10 December 2015

Oakdale South Estate – Review of the SLR September 2015 Noise Impact Assessment

- *DA Noise Impact Assessment, Oakdale South Estate, Milner Avenue, Eastern Creek, Report Number 630.11166, Revision 2, 8 September 2015*

Figure 1 SLR noise logging locations (extract from SLR Report)

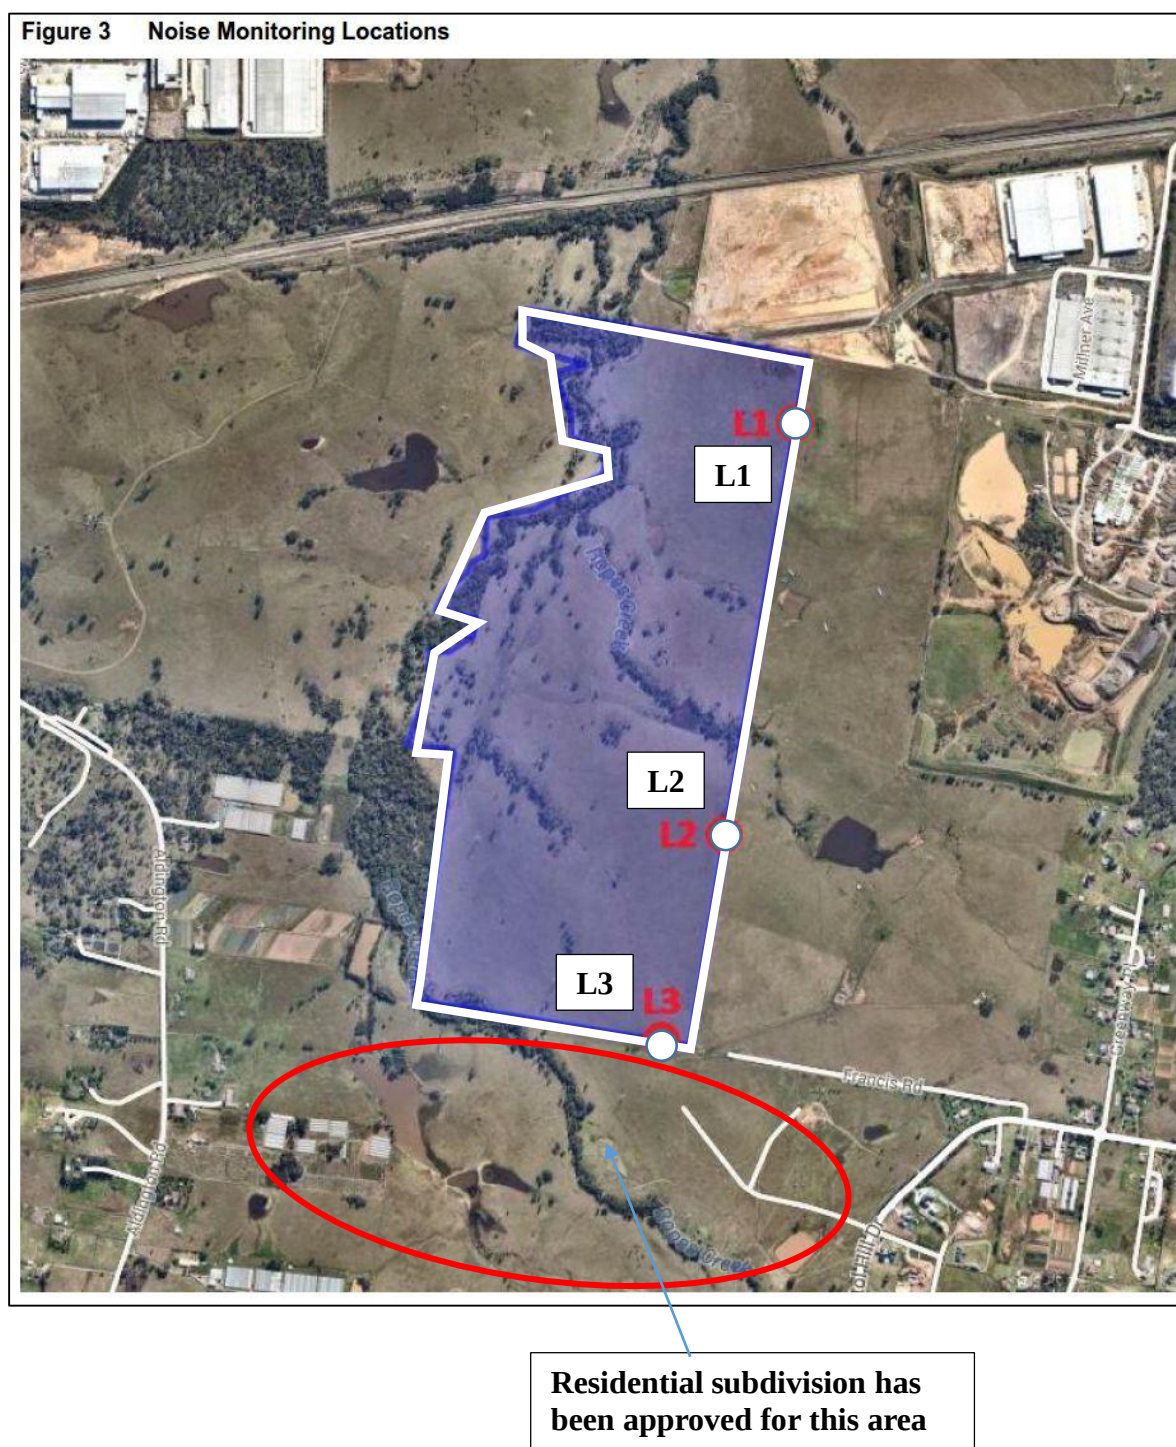
The background noise monitoring carried out by Wilkinson Murray found frequent periods during night-time when background sound levels were below 30dBA. The SLR Report assumes that the background sound levels are:

At the very least, the noise loggers used for the SLR assessment should have had filters to exclude insect noise. In addition, night-time sound level measurements should have been carried out once it was clear that the background sound levels were anomalous.

The WMPL Report labelled this area as “Future Residential” but Residential subdivision has been approved for this area

Further, the planning authorities have not considered the cumulative noise impacts of both of the proposed industrial sub-divisions shown in Figure 1 and Figure 2. This is a gross oversight since it is known and understood that the whole area north and north-west of Francis Road will be developed for industrial use. To consider each development individually is simply to understate the cumulative noise impacts.
